RESERVED MATTERS PLANNING APPLICATION, REFERENCE H09-1044-23, ERECTION OF 285 DWELLINGS INCLUDING PARKING, PUBLIC OPEN SPACE, DRAINAGE, INFRASTRUCTURE, LANDSCAPING, ACCESS, APPEARANCE, LAYOUT AND SCALE (PHASE 3) - OUTLINE APPROVAL H09-0521-14 AND RE-SUBMISSION OF H09-0845-22 AND H09-1118-22.

Please find attached amendment form and updated documents in relation to the above Reserved Matters Planning Application, reference H09-1044-23.

SECTION D-D
Scale 1:100

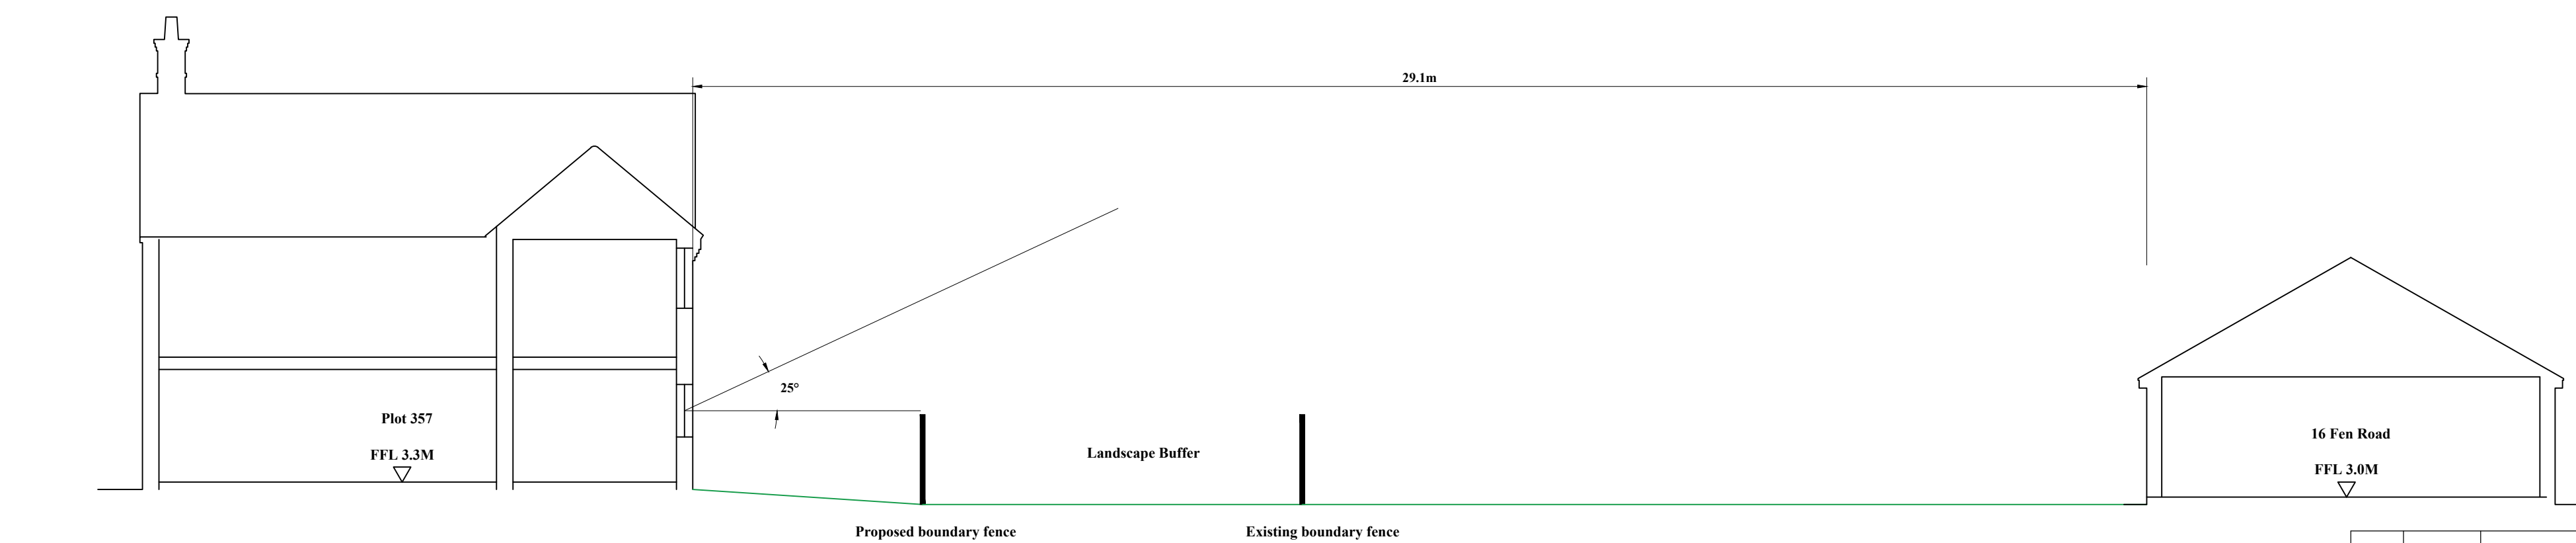
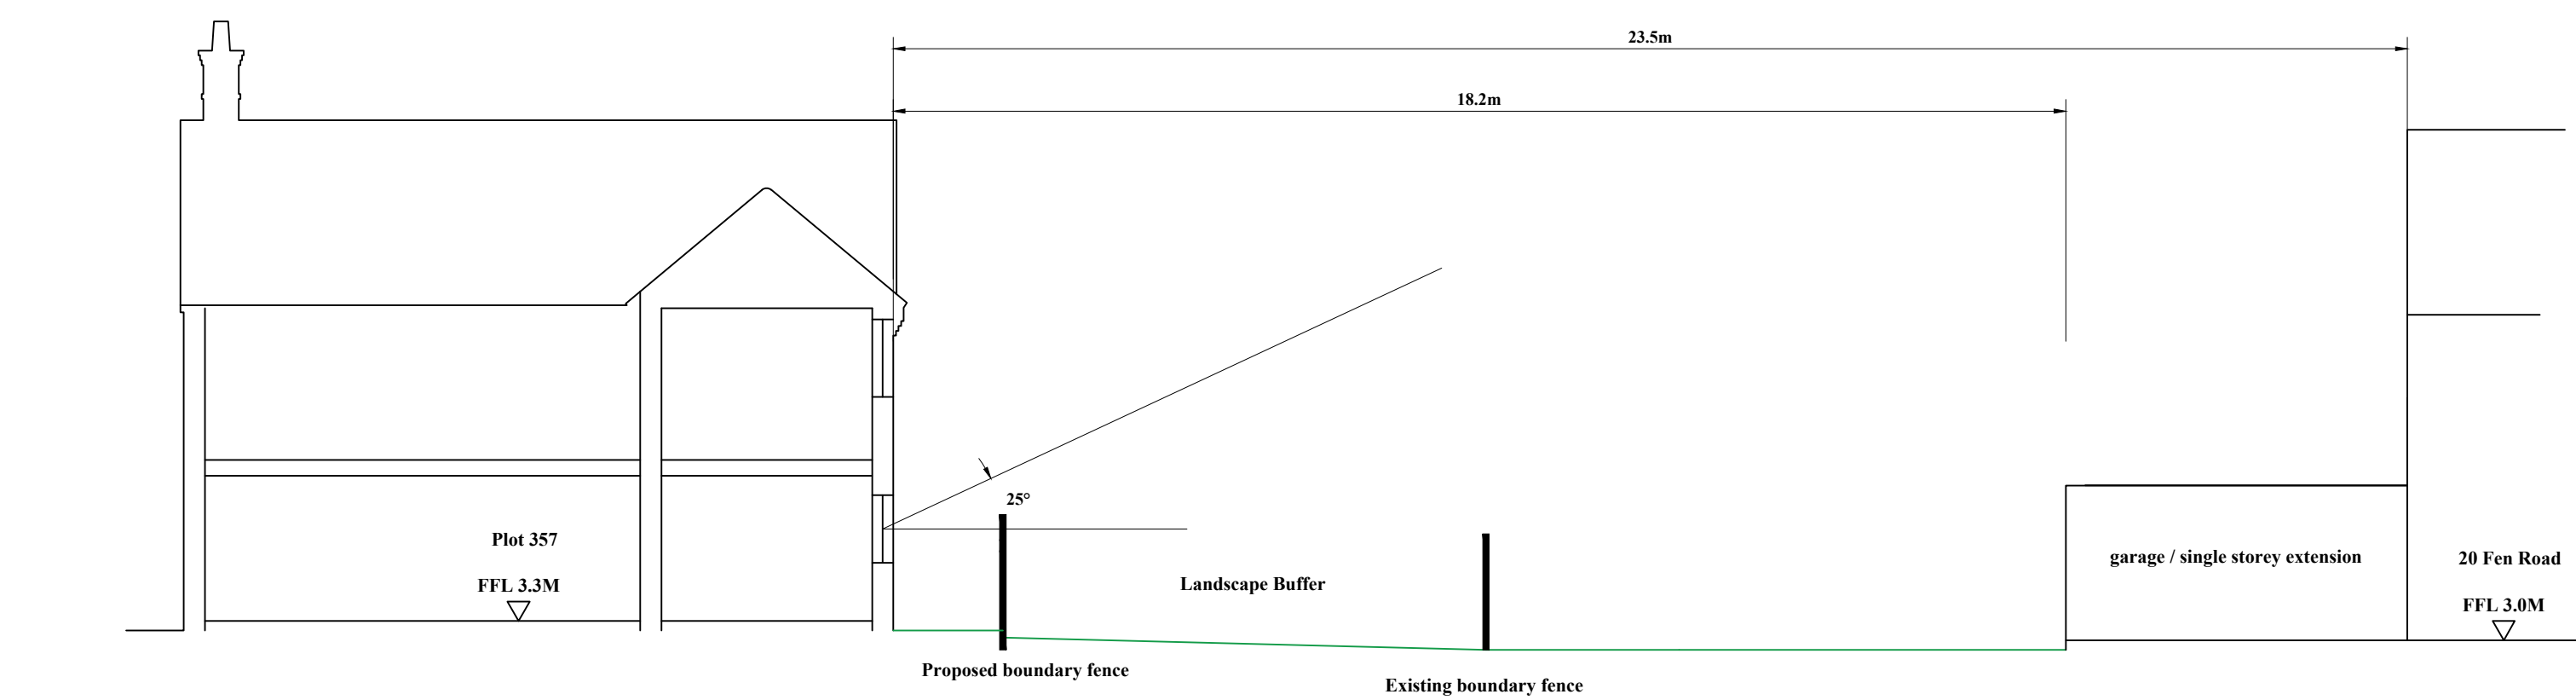
- Garden sizes – we have noted dimensions on the layouts and made some tweaks where necessary to ensure a 8m garden dimension generally. We would prefer to remove these dimensions on the formal submission.
- Housetype schedule – ref attached 137-HS-10 rev B which also states the affordable mix to be provided.
- Shared triple garage 4 – this has been amended to better reflect the other garages.
- Coronation and Stamford – we will add flank windows to the side elevations on these plots which generally face onto their parking. This will be reflected on revised design sheets to be issued when we do the formal submission.
- Plots 349 and 357 rotated and garden fencing moved away from Fen Road plots to create a larger landscape buffer. Sections added to this boundary on drawing 137-SS-15 Rev A Site Sections.
